Response to Planning Application

From: Arun District Council Greenspace

Application ref: AL/21/20/OUT

Location: Land North of Lee's Yard Lidsey Road Woodgate PO20 3SU

Land At Lidsey Road
Indicative Proposed Site Plan

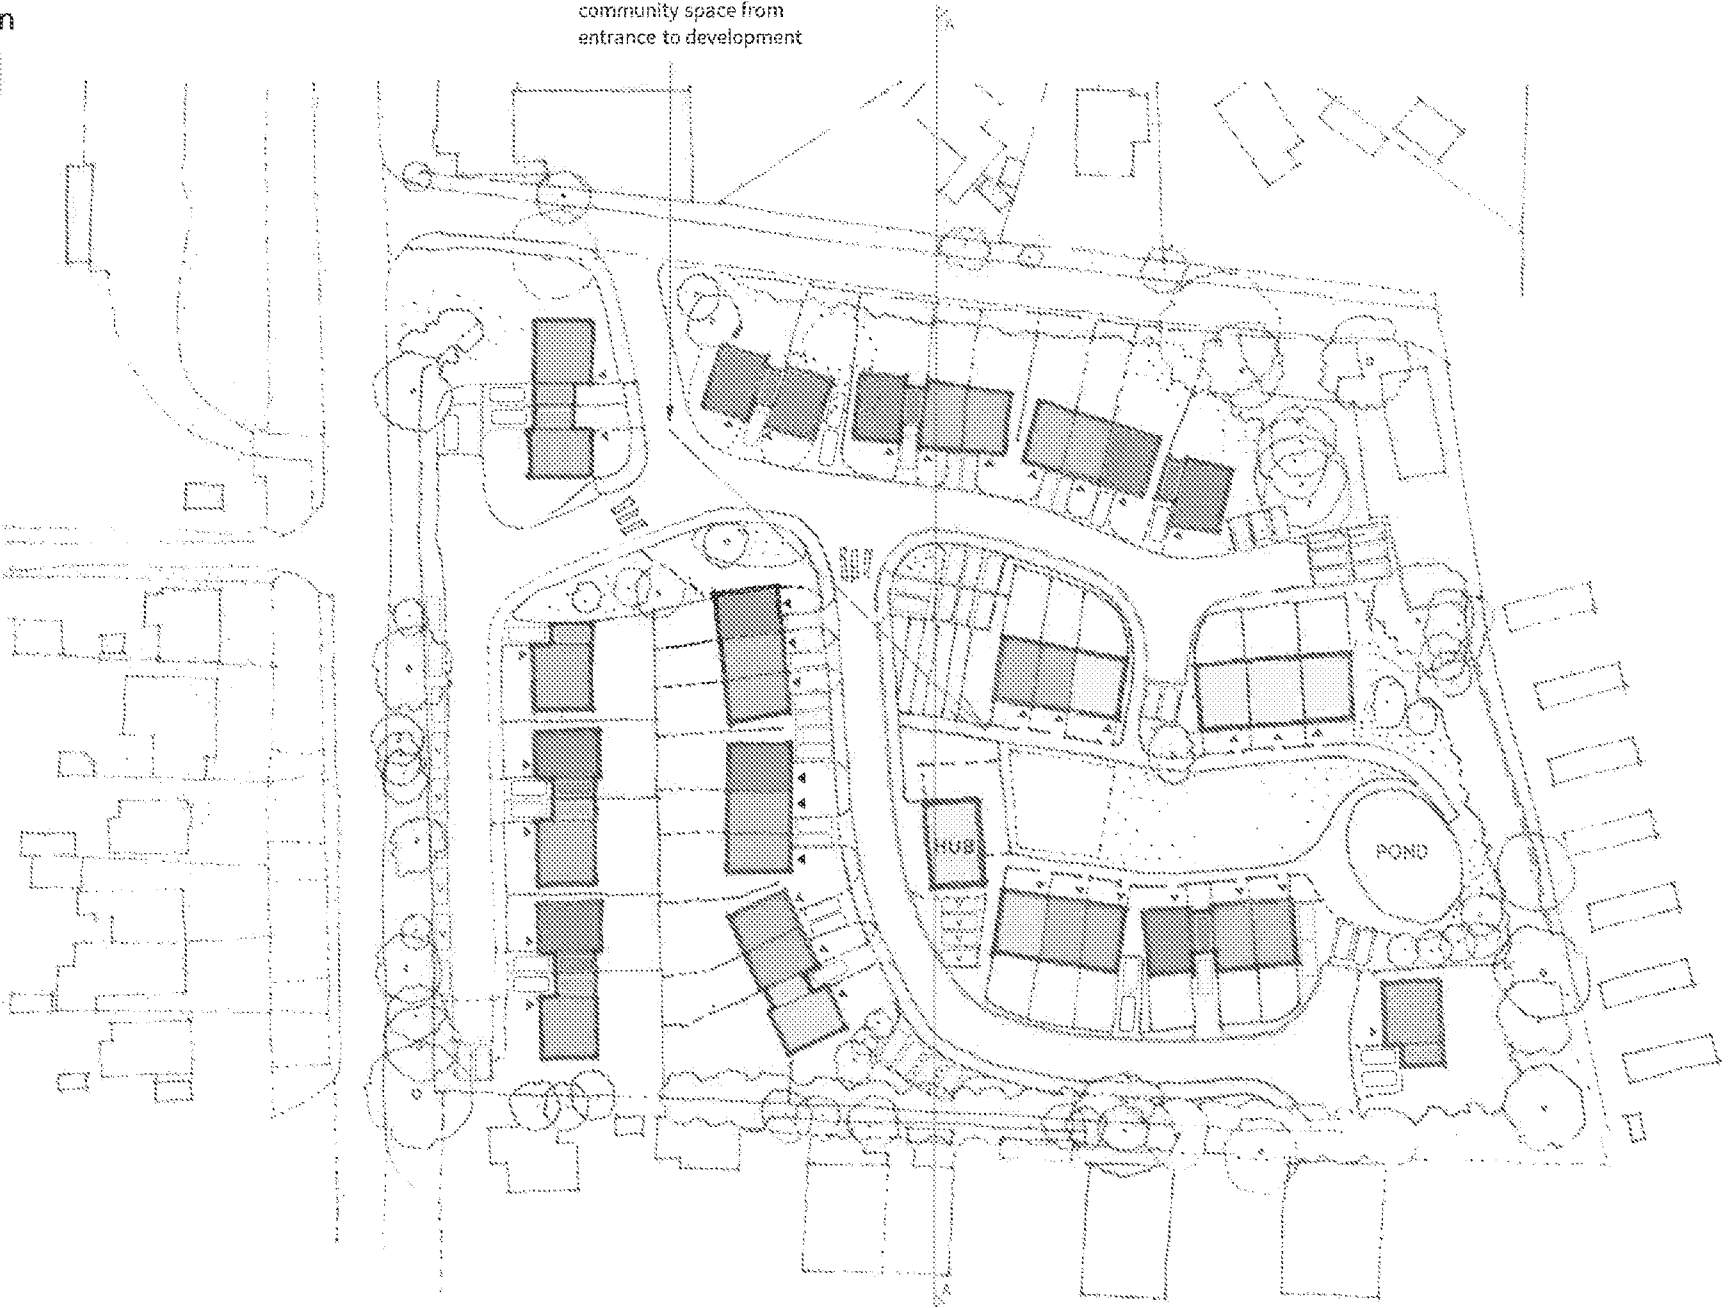
The indicative layout has shown 38 dwellings within the proposals with an area of POS, located centrally to the development and buffer planting to perimeter, largely to accommodate existing trees. Consideration should be given to facing dwellings onto POS areas in line with good design principles.

A development of this size will require the provision of onsite POS minimum area of 2,675m² plus the provision of onsite, unequipped natural play LAP to include such features as landform, boulders or logs, seat and litter bin and onsite equipped LEAP 460m². Confirmation of the area of POS being proposed would be required.

The indicative layout appears to show an area detailed as pond within the POS area. Should the need for SuDS be required with the development then these areas should not be included in the total area of usable POS calculations. Further detail would also be required regarding depths and indication of timeframe for water holding periods ie dry feature or water holding body. This would be particularly relevant because of the proximity in relation to play and dwelling boundaries.

Consideration of existing trees and hedges within the site would be required and any removals agreed with Arun District Councils Tree Officer. Existing vegetation to the perimeter of these proposals may conflict with private gardens and come under pressure to be removed or pruned. It is good to see that the indicated green buffer shown to the boundaries of this development would go some way to accommodate existing trees and allow for their retention.

Pedestrian and cycle routes within the development should be a considered design features and their meaningful connection to beyond the site detailed.
